Appeal Decision

Appeal Ref: APP/R5510/W/24/3351213

123A Central Avenue, Hillingdon, Hayes UB3 2BS

- The appeal is made under section 78 of the Town and Country Planning Act 1990 (as amended) against a refusal to grant planning permission.
- The appeal is made by Mr J Singh against the decision of the Council of the London Borough of Hillingdon.
- The application Ref is 78009/APP/2024/1578.
- The development proposed is alterations and extension to existing part single/part two storey side extension to create new end of terrace dwelling with associated amenity, parking and bin storage.

Drawing Title: Proposed Ground Floor Plan Client: Jarnail Singh Date: 18/05/2024 Drawn By: SY
Status: Plans Proposed Scale: 1:500, 1:50, 1:100 Project No: 1037 Drawing No: 1037-12 Rev: Rev_08
Plans Proposed @A2

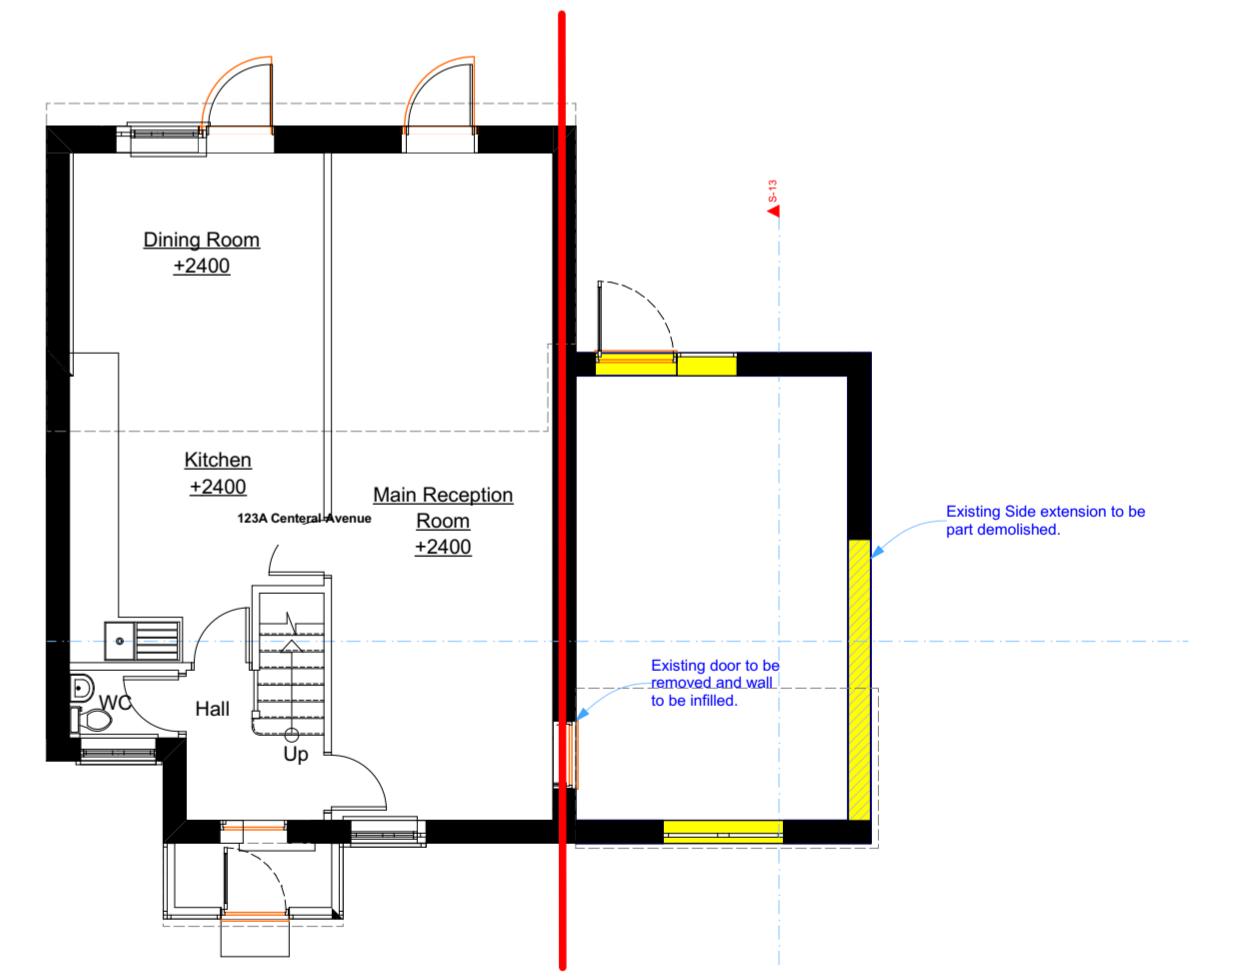
8. The proposed rear garden would be very small which is uncharacteristic of the area, particular the spacious corner plots. Furthermore, an area of garden is proposed to the front of the dwelling which with the potential for domestic paraphernalia to be present would further erode the spacious character and appear as an incongruous feature in the context of the mostly open frontages in the wider area.

10. Policy DMHB 18 states that all new residential development, and conversions will be required to provide good quality and useable private outdoor amenity space. In terms of the amount of space a one-bedroom dwelling should provide a minimum of 40sqm and there is no dispute that the proposal would provide more space than this minimum standard.
11. A small section of the amenity space is proposed to the rear of the dwelling but its narrow width and particularly narrow sections next to the proposed dwelling would make it an unattractive space for future occupiers to use.

12. The majority of the proposed outdoor amenity space is to the frontage of the dwelling which as a result of a 0.5m high fence and hedge it would be clearly visible by people passing the site. I note the appellants considers that each zone of the outdoor space could be used for different purposes. However, the most usable and attractive space would be at the frontage which would only be screened by a low fence and would provide a lack of privacy for future occupiers to be able to use the space. I am not convinced that a condition could address the lack of privacy without harming the character and appearance of the area.

Proposed Elevations

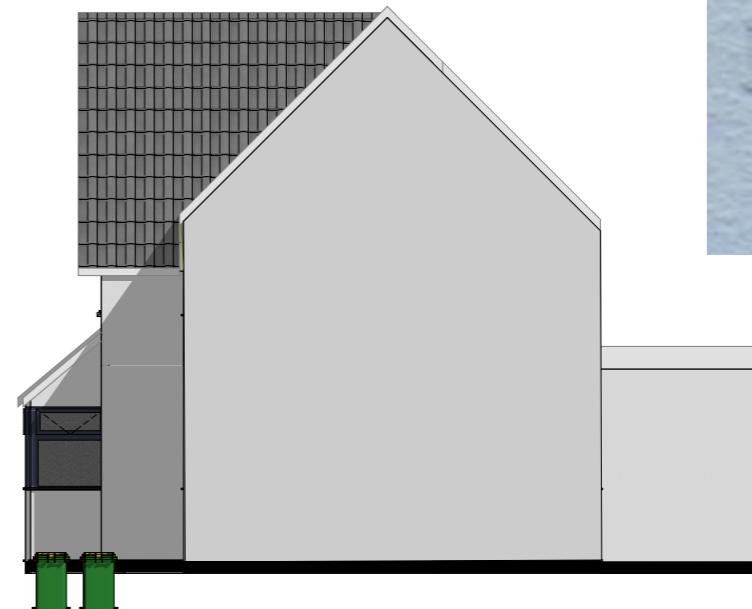
5. The appeal property has already been extended with a two storey side extension. However, the extension is subordinate to the main dwelling by virtue of its set down from the ridge and set back from the elevation at first floor level. The proposal would utilise the extension but would match the ridgeline and building line of 123A as well as increase in width.

6. The proposal would appear as an extension of the existing terrace which would result in the terrace being overly long and cramped within the plot, despite the proposed set back. The overall width would also erode the spacious gap which would further highlight the cramped appearance of the development.

7. I note that the existing two storey extension was considered acceptable at appeal¹ and I agree that there is variation in the size of undeveloped side outdoor spaces in the area, including that they are generally not uniform. However, I do not consider the increase in width to be minor, instead, the increase, as well as the other concerns would upset the uniformity of the street scene and result in an uncharacteristically small gap to the side.
